PLANNING CONSULTATION RESPONSE

Application No	2026/0420
Proposal	10 x 2/3 storey dwellings
Address	Land west of Sheffield Road, Birdwell, Barnsley
Date of Consultation Reply	14 th August 2026
Consultee	Councillor Betty Barnes

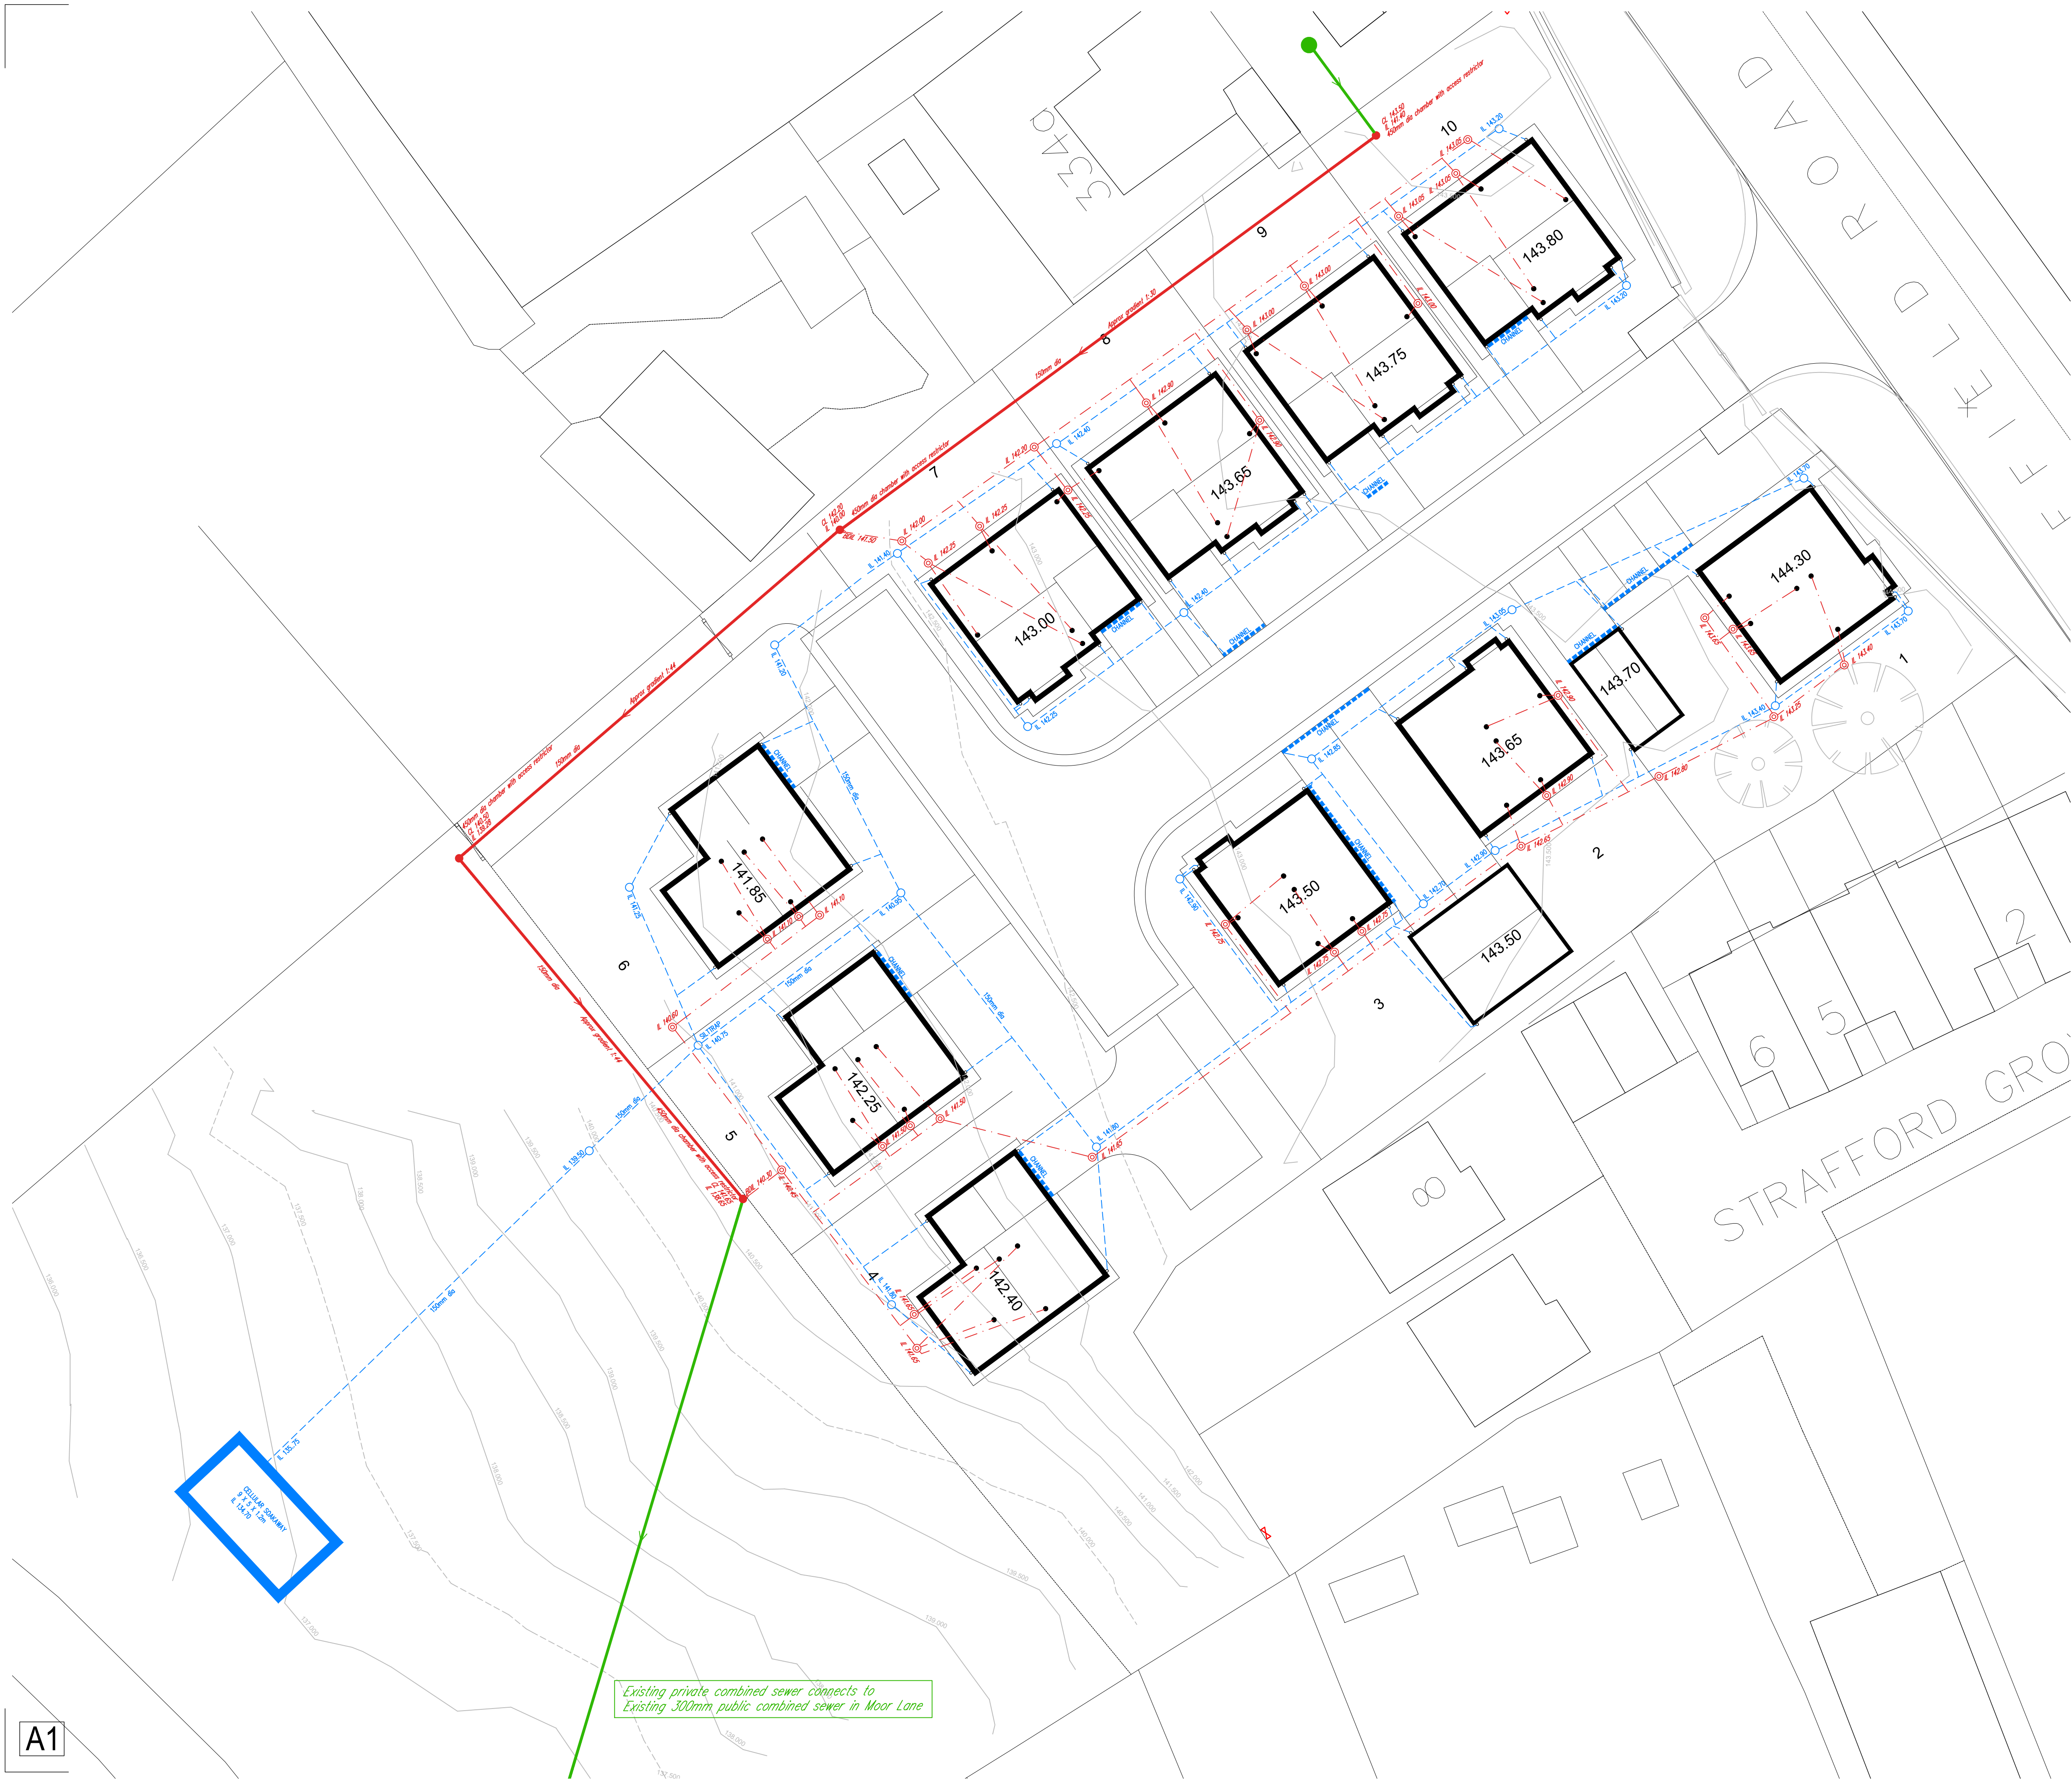
- Whilst the private soakaway calculations appear to evidence that the soakaway can accommodate the proposed volumes both National Highways and Barnsley highway drainage team are concerned with the proposed location of the soakaway relative to the motorway embankment. It is particularly important that any risks associated with this are fully explored and can be appropriately mitigated.
